STATE OF NORTH CAROLINA
DEPARTMENT OF TRANSPORTATION

Addendum No. 1

Dare County (F-5700)

Construct 183'-7" X 46' X 10'-6" Passenger/Vehicle Ferry

SIZE	D	DWG NO.	16101-200-120-4	REV	B
SCALE	1/2" = 1'-0"	FILE NAME	16101-200-120-4B	SHEET	2 OF 6

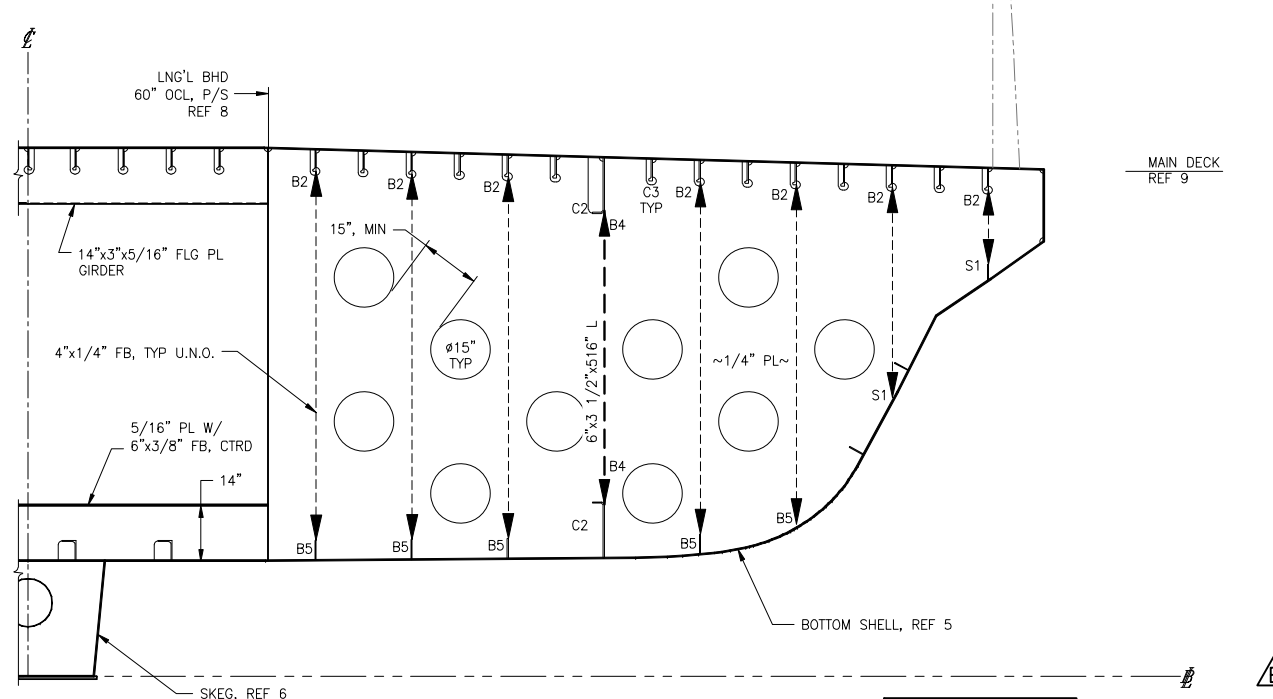
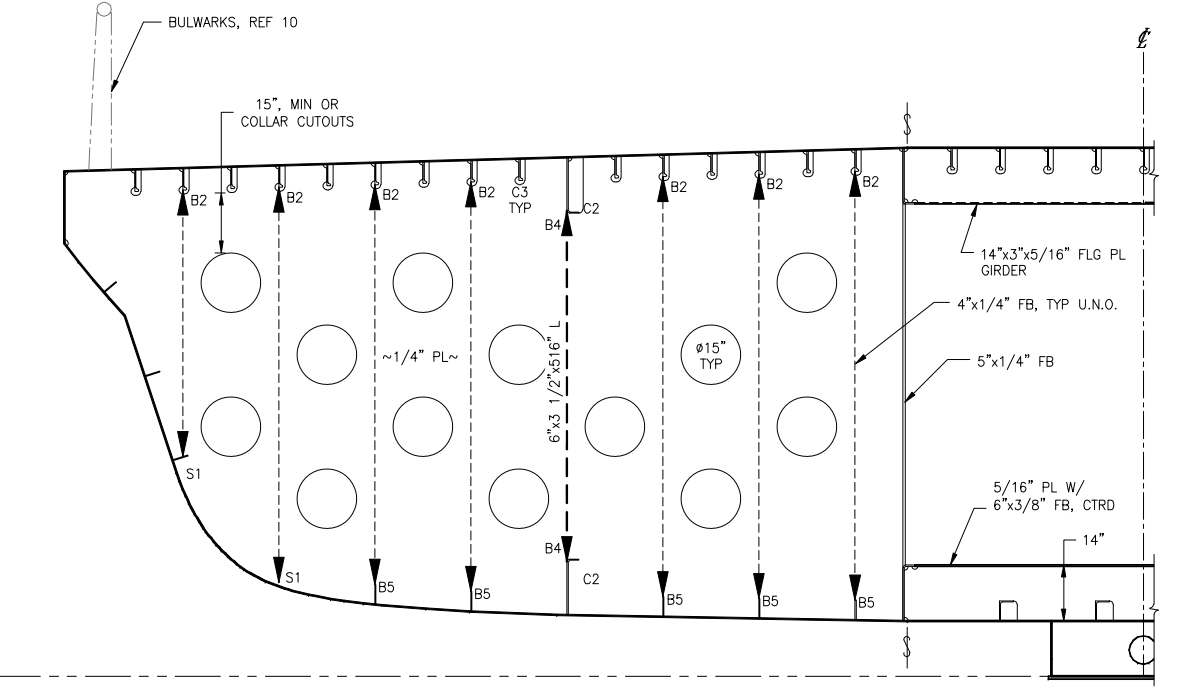
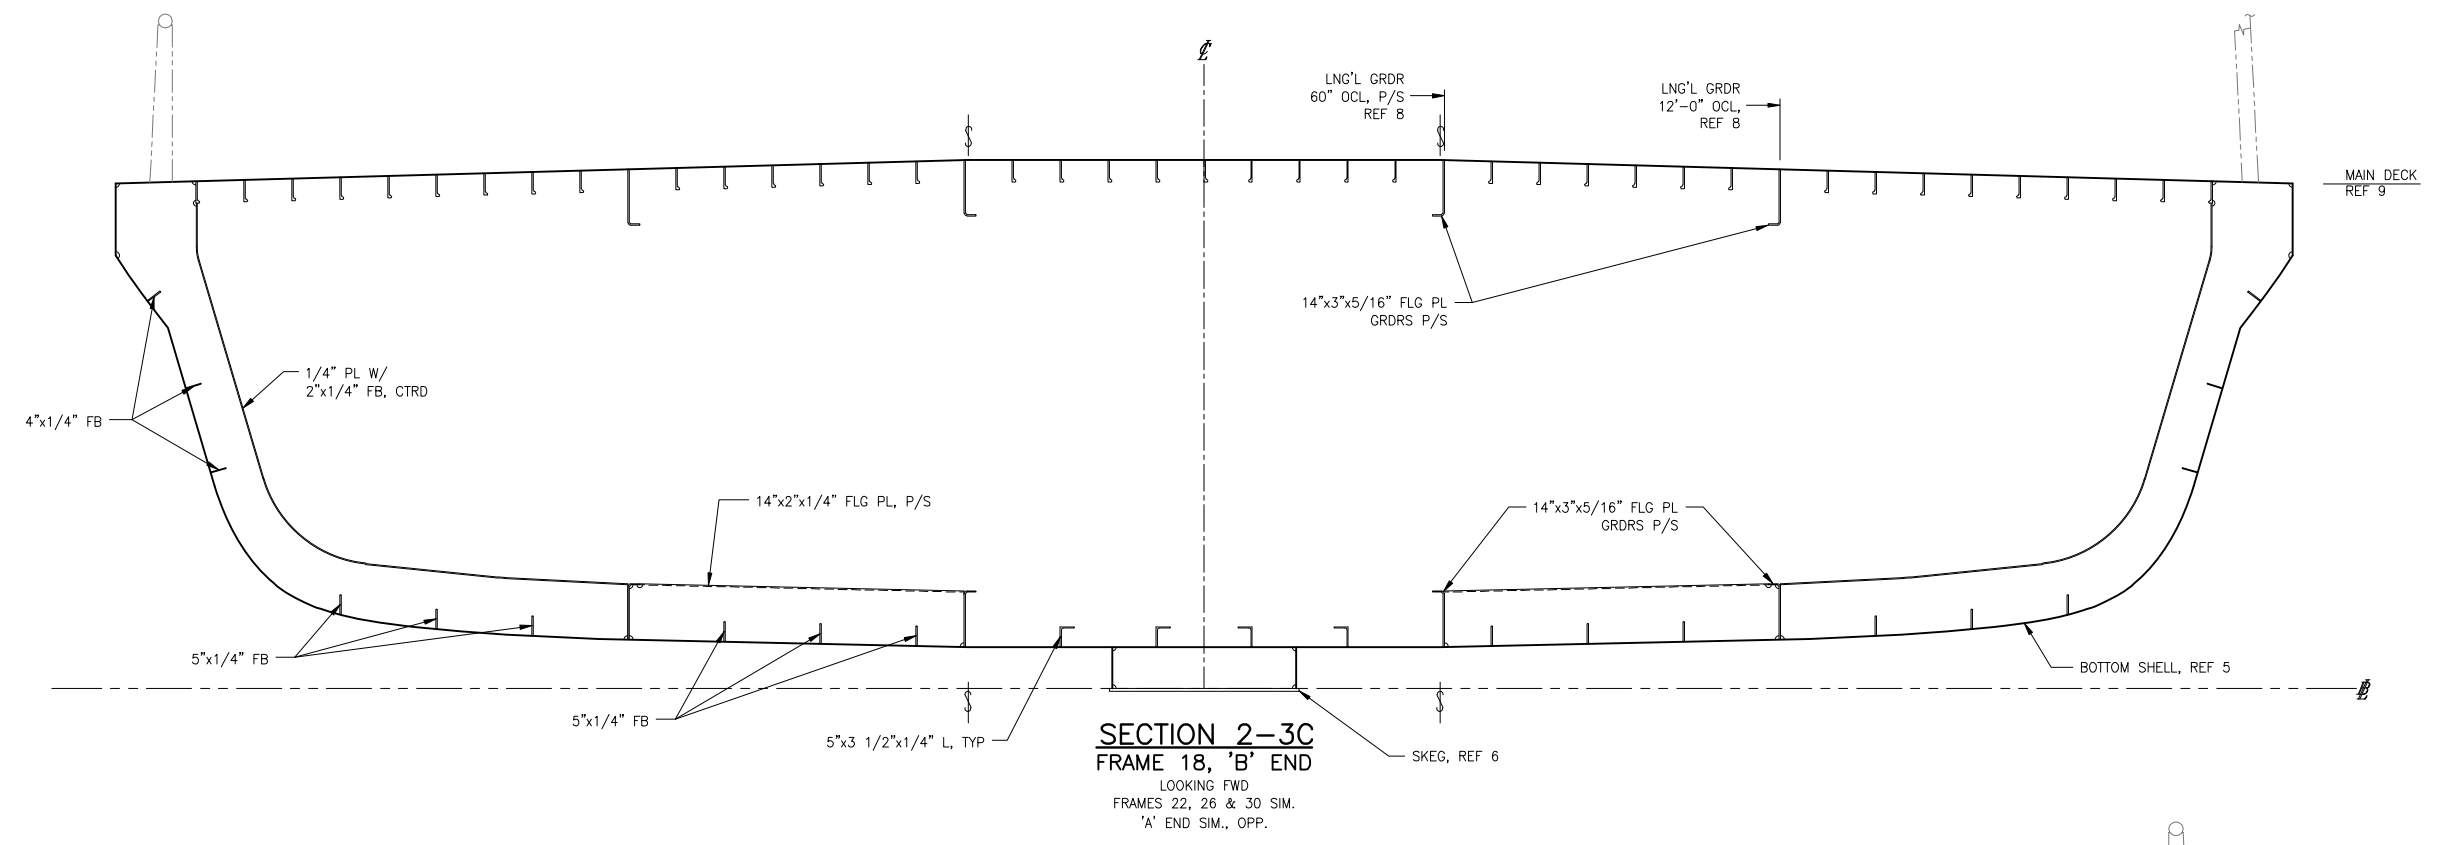
Hull Transverse Frames
120-4: Sheet 2, Zone 2A	Added view 2-2A for Frame 28
120-4: Sheet 2, Zone 3A	Updated tonnage frame lightening hole scheme to clarify
120-4: Sheet 3, Zone 4A	Updated tonnage frame lightening hole scheme to clarify
	Main Deck
130-2: Sheet 1, Zone 2B	Updated material description of insert plates at ends
130-2: Sheet 1, Zone 4A	Added manholes and hatches and updated cleat inserts locations
130-2: Sheet 2, Zone 3A	Added manholes and hatches and updated cleat inserts locations
130-2: Sheet 2, Zones 5C & 6C	Updated material description of insert plates at ends
	Superstructure Main Deck to 01 Deck
150-1: Sheet 1, Zones 2B & 6B	Updated location of mast support structure a and b end
150-1: Sheet 1, Zone 6C	Added hatch cutout
150-1: Sheet 3, Zone 1B	Updated emergency generator room bulkheads / louver cutouts
150-1: Sheet 4, Zone 4A	Updated emergency generator room bulkheads / louver cutouts
